From: Brigit Foster
Sent: 11 February 2021 12:58
To: Planning
Cc: Tom Peacock
Subject: Planning application: 21/00024/VAR - 20 Osler Road Oxford OX3 9BJ

Application number 21/00024/VAR
Address: 20 Osler Road Oxford OX3 9BJ
Application - variation of condition 2 (Develop in accordance with approved plns) of planning permission 20/00184/FUL (Demolition of existing dwelling and garage. Erection of 1 x 3-bed, 2 x 2-bed and 2 x 1 bed flats (Use Class C3). Provision of private amenity space, bin and bicycle stores (amended description and plans)) to allow alterations to rear roofslope and insertion of 2no. rear rooflights, insertion of solar panels to side elevation and alterations to fenestration.

21 Osler Road	Date: 04.01.2021
OX3 9BJ	Scale: 1:100 @ A3
	Status: Planning
	Drawn: RK
Proposed Side Elevations	
190278 - A - EL - 211	Revision: B

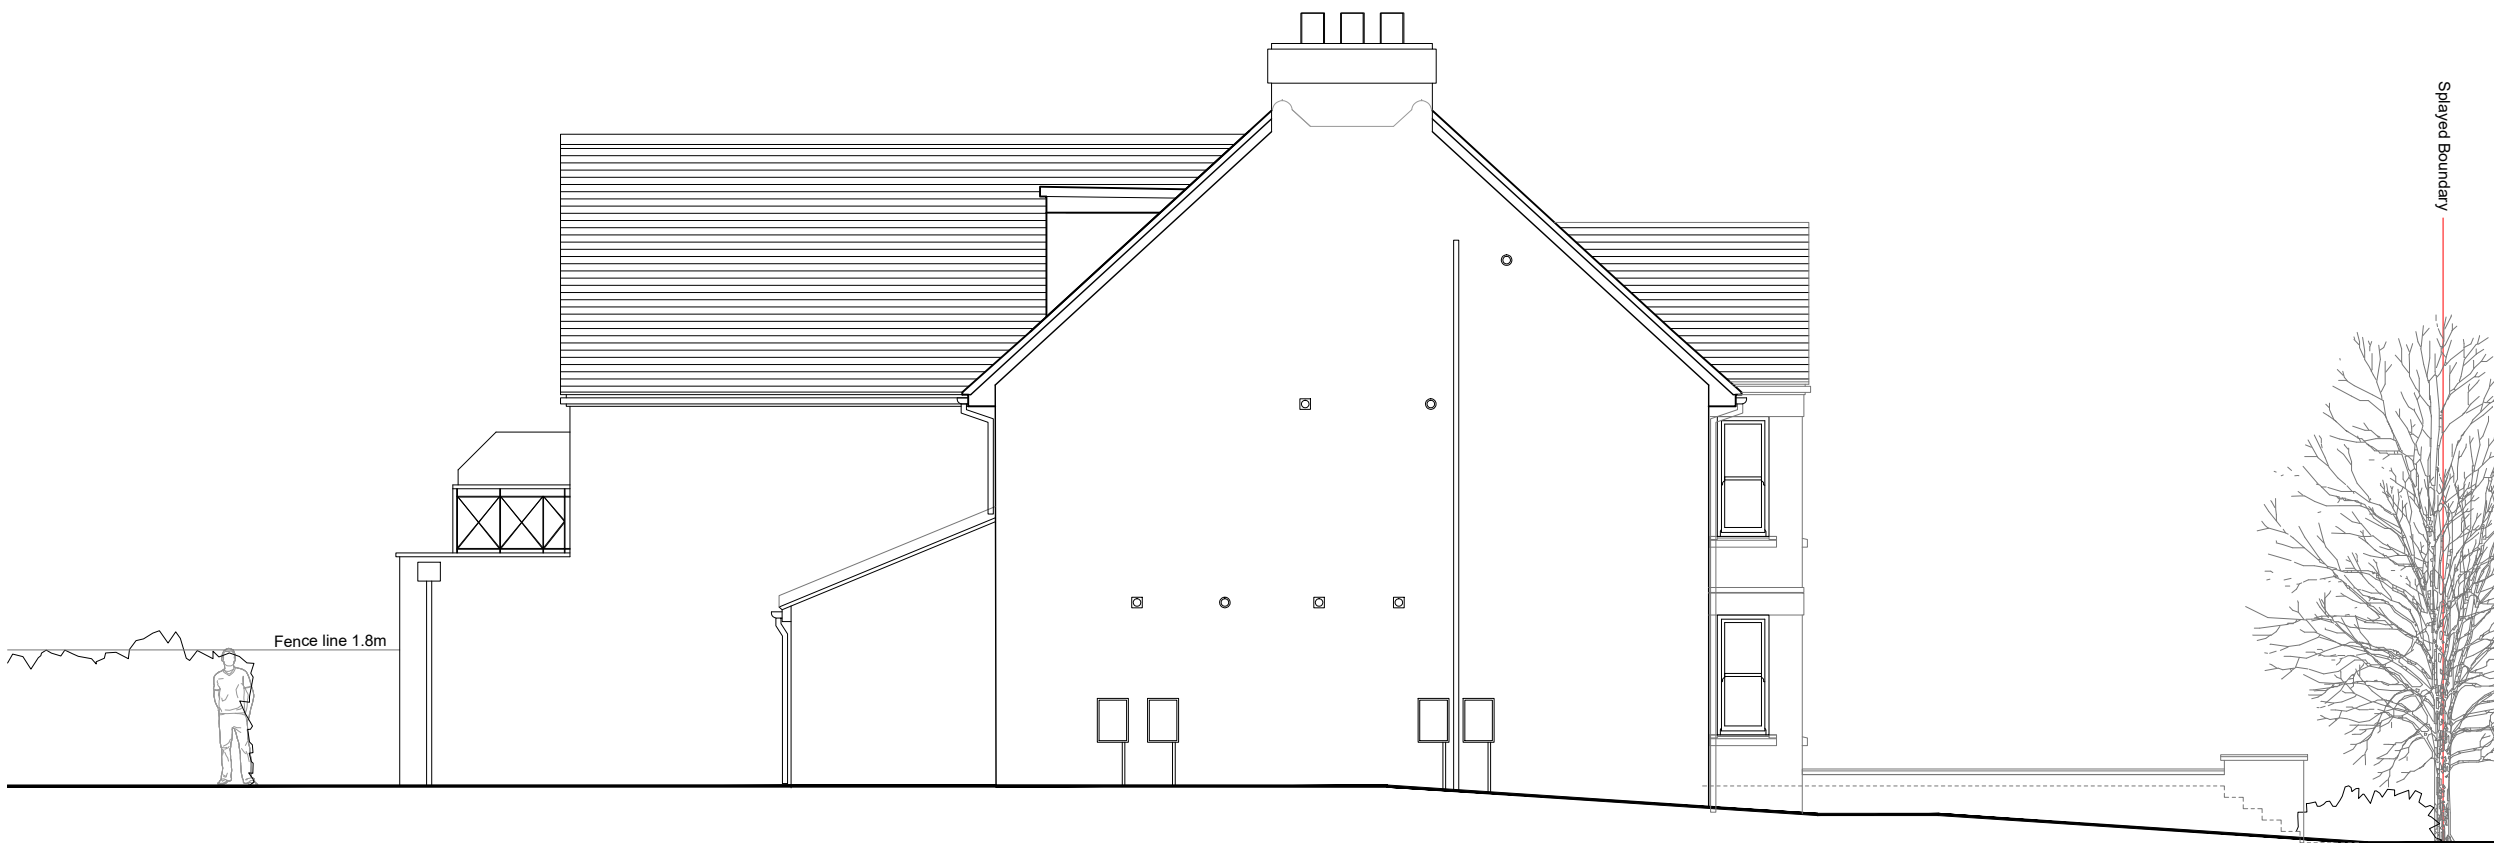
1. the side elevation shows that the applicant is increasing the pitch of the roof and consequently the volume of the building. The effect of this is that the building will be even bigger and more overbearing for neighbours;
2. the applicant has provided incomplete information: given that the new design has increased the volume of the 2nd floor, why haven't they submitted a plan of the 2nd floor as they have for the ground & 1st floors? It would appear that they are trying to cram more into the space; and
3. from the drawings it looks like they have moved the rear wall out slightly to the east which will negatively impact neighbours.

It is unclear from this application why the applicant would now decide to add rooflight windows. The conclusion must be that the applicant is incrementally ratcheting-up the size, scale and footprint of the building to the detriment of existing residents and therefore this application should be rejected.
